Demolition of existing buildings & erection of 3 No. dwellings with associated parking,
alterations to existing access & relocation of staircase to flats.

Land Rear of Beechlands Cottages Beechlands Close East Preston

**OBJECTIONS TO PLANNING APPLICATION EP/138/17/PL LAND TO REAR OF
BEECHLAND "COTTAGES"/ NORTHERN PARADE OF SHOPS EAST PRESTON**

Proposed Site Plan, Block Plan
and Location Plan

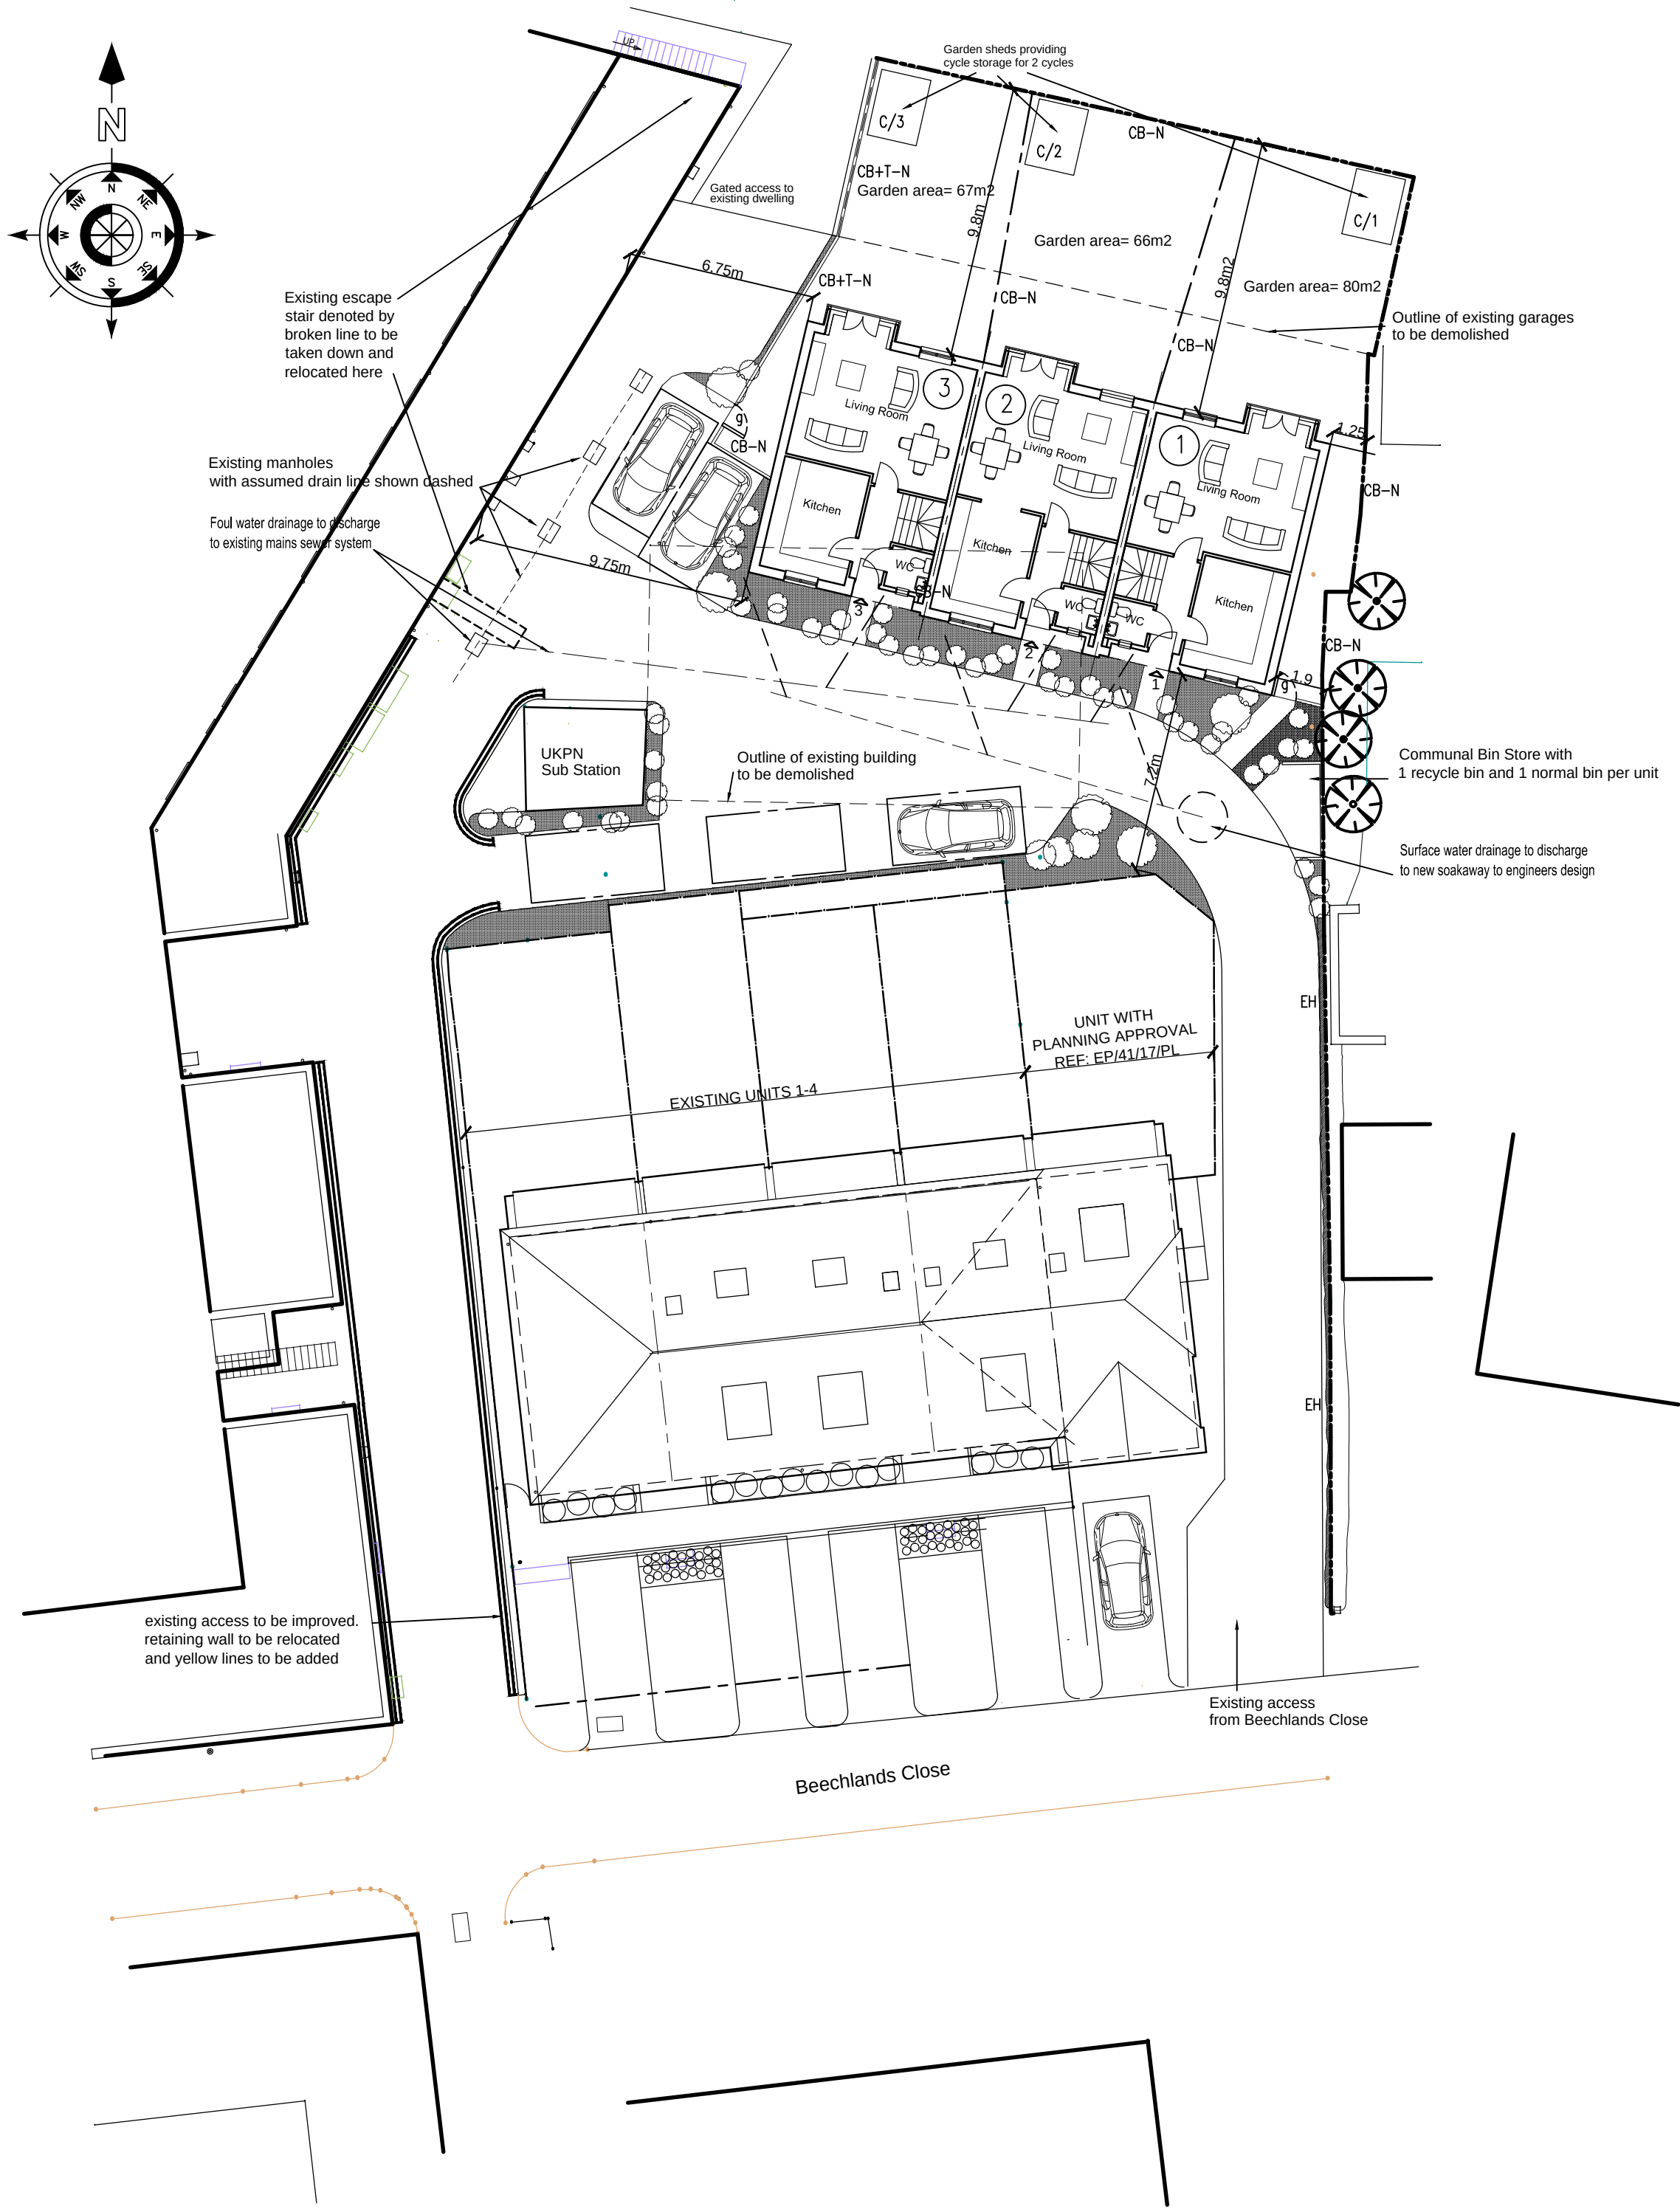
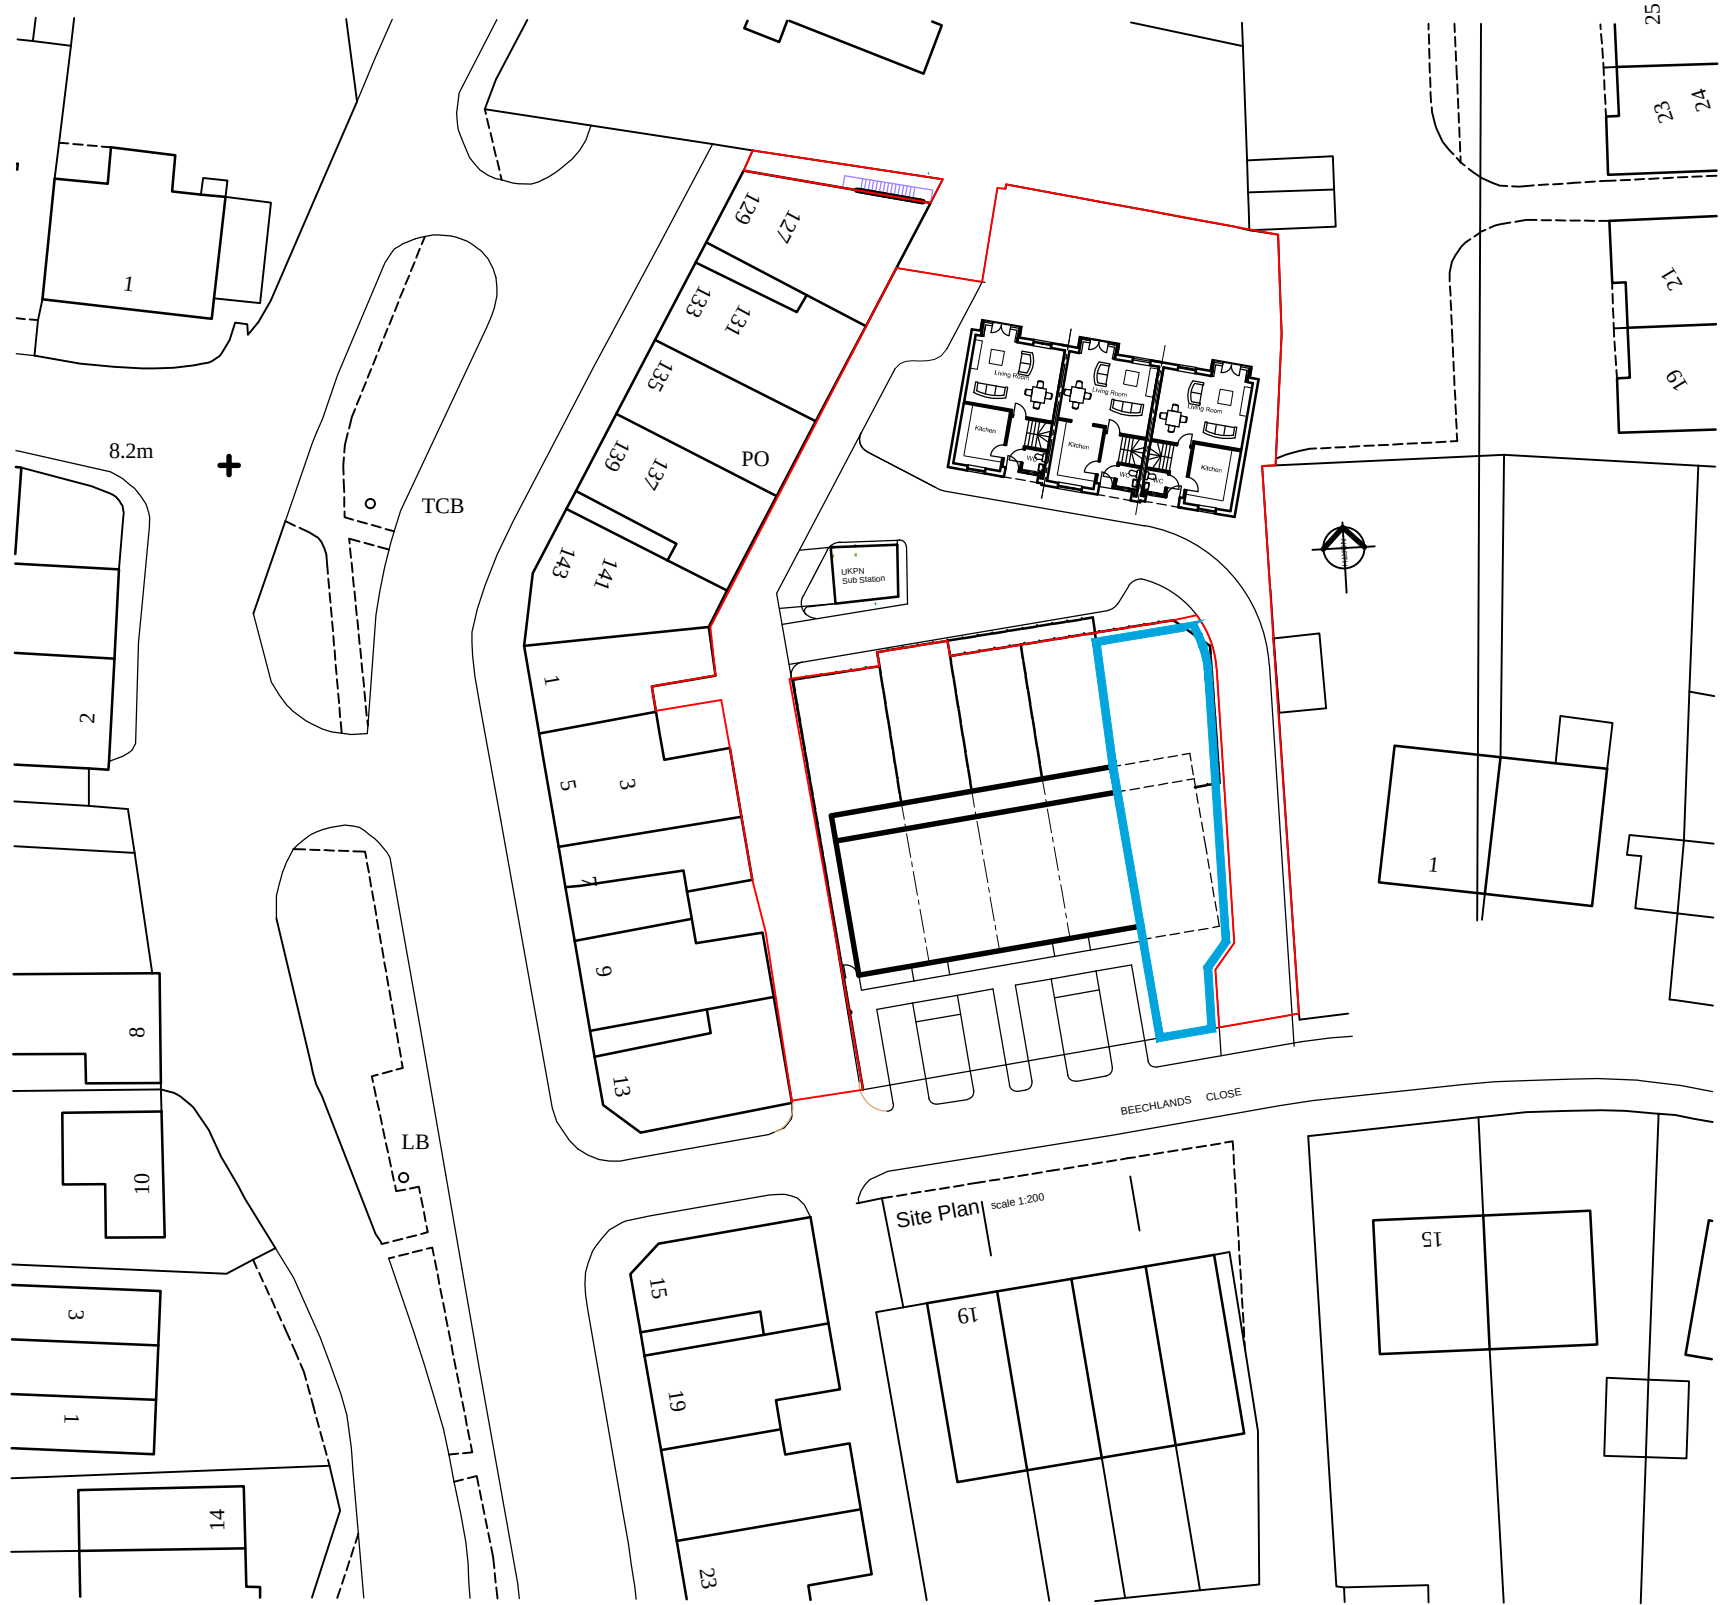
The occupants of these proposed dwellings will have a clear view into our home if they are built, their views would be further enhanced by the reduction in the height of our existing 2.7 metre high boundary wall (forming the back of the garage) which is reduced to an 1800mm high wooden fence on the plans.

The proposed development seeks to severely restrict the vehicular and pedestrian access route to our property making it difficult to ingress and egress safely for us, family, friends and deliveries who are entitled to do so.

The severely restricted route with tight bends and radii to Beechlands Close would be impossible to negotiate when towing our race trailer or when friends and family visit either in their motor homes or other vehicles as they do so at present (see photo attached).

The 2 parking spaces shown at the Western end would block our existing access and would not be possible if the plan were correct in detail and the metal staircase was to remain in its present position.

No provision has been made for our pedestrian visitors or others using this now narrowed route with regards to their safety either by way of a pavement or lighting. There is no consideration on the plans for parents with children in prams or the elderly when

DRAWING TITLE
Proposed Plans and Elevations

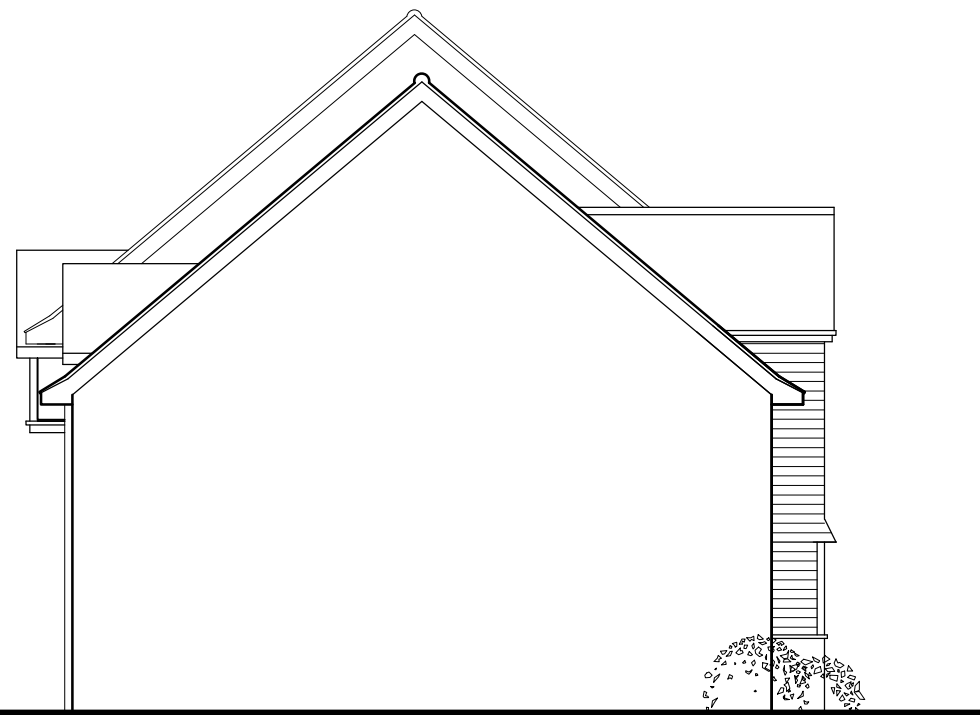
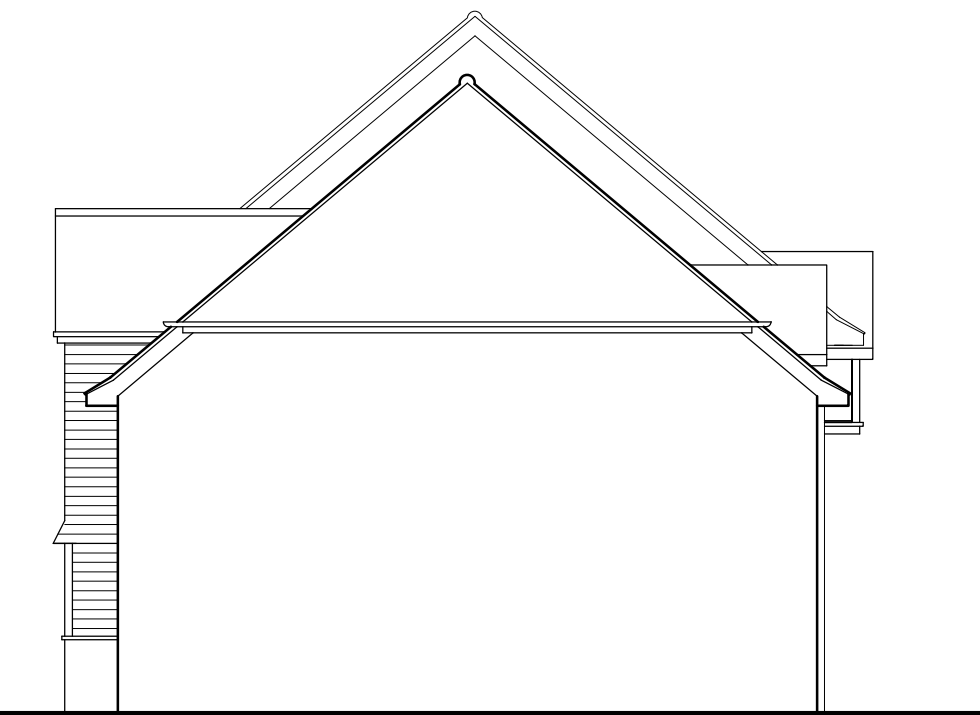
The design of the proposed dwellings will cast a shadow on our garden and severely restrict any sun particularly from sunrise to midday during the winter months when it is at its lowest.

The design and height will have an overbearing impact on us by invading our privacy and considerably reducing the enjoyment of our property.

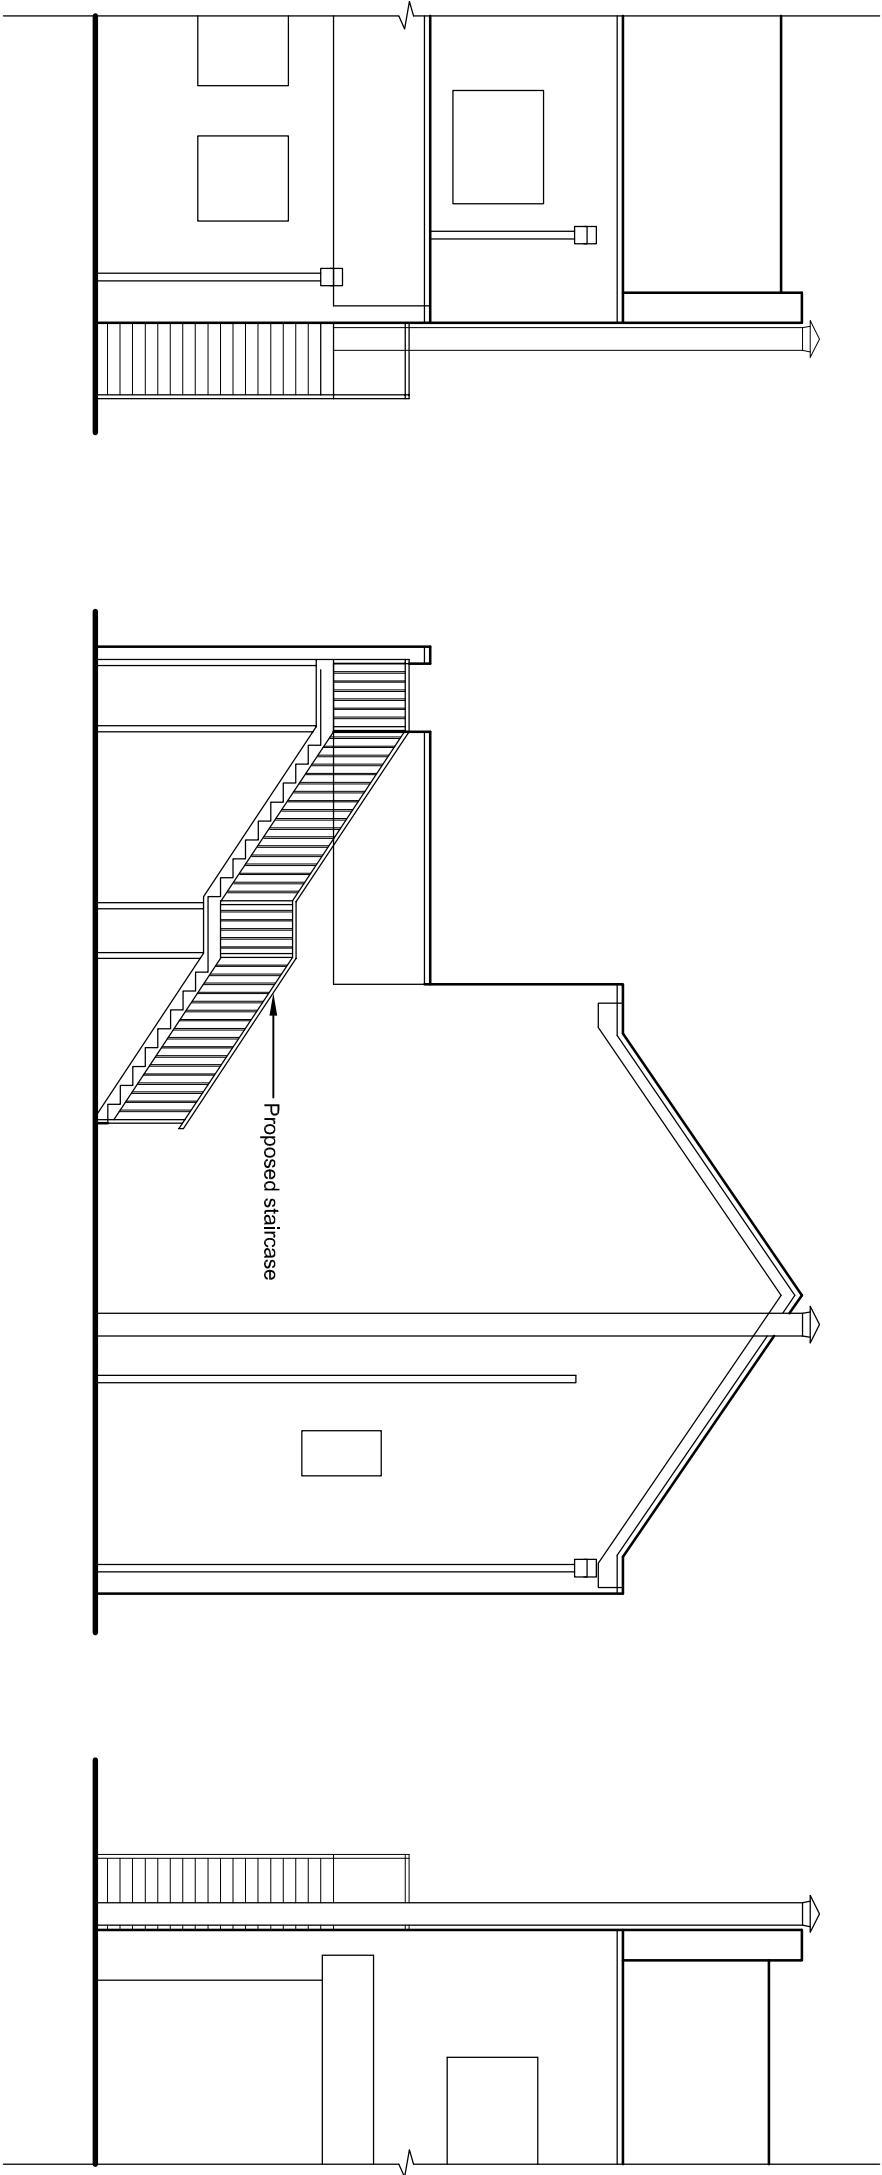
The re-positioning of the metal staircase on the Northern end of the existing balcony to the rear of the flats would be unsightly and intrusive. It would interfere with our privacy as it's proposed position is adjacent to our conservatory / dining area and open to the general public.

As an escape it would require the unlocking of the gate at the end of the alleyway which has been closed to all since the mid-eighties, this to allow permanent egress/ access to anyone including the public.
